CITY OF ALBUQUERQUE

March 14, 2019

**Re: Maverik – 1401 and 1415 Wyoming Blvd NE
Erosion Sediment Control Plan
Engineer's Stamp Date 12-7-18 (J19E049)**

ENGINEER'S SEAL	MAVERIK 1401 WYOMING BLVD. NE EROSION CONTROL PLAN	DRAWN BY RS DATE 12/7/2018
			2018055-SWPPP
RONALD R. BOHANNAN P.E. #7868	 <i>TERRA WEST, LLC</i> 5571 MIDWAY PARK PLACE NE ALBUQUERQUE, NM 87109 (505) 858-3100 www.tierrawestllc.com	SHEET # ESC-1	
		JOB # 2018055

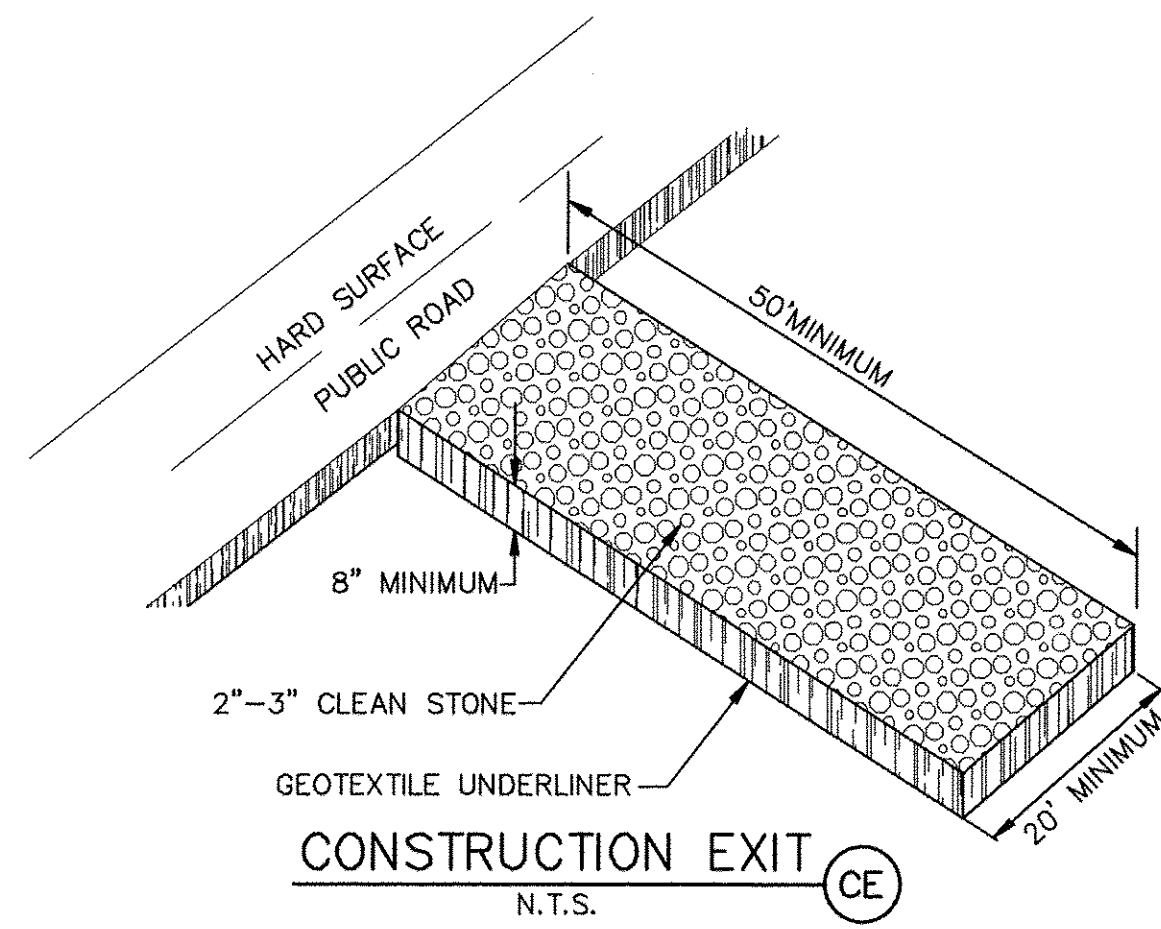
1. Provide proposed grades, including FF of building.
2. Label existing grades so they are legible.
3. Provide a detail for the Silt Dike BMP shown on the plan. The surface in this location is impervious, so it will have to form a seal.

4. In the existing condition, west is downhill. Disturbance is shown west of the silt dike and the disturbance limit is west of the silt dike.
5. Silt fence is proposed on an impervious surface. It won't seal on the asphalt. A filter sock or similar is necessary at the toe of the silt fence.

6. If proposed grades along the northern edge are higher than existing grades on the property to the north a sediment BMP is required. Grading information on the plan should make this clear.

7. A proposed contour is shown east of the east limit of disturbance.
8. If the sediment basin shown in the southeast corner of the site is uphill, it is not practical to "Provide positive drainage to sediment basin during grading operations" and this note should be removed.

9. The canopy drain appears to dead end and is located in the center of the Construction Exit. Is a drain to be built in this location? How will track-out be managed when it is being installed? This location is also the historic drainage outfall, which increases the potential for sediment to be transported offsite.
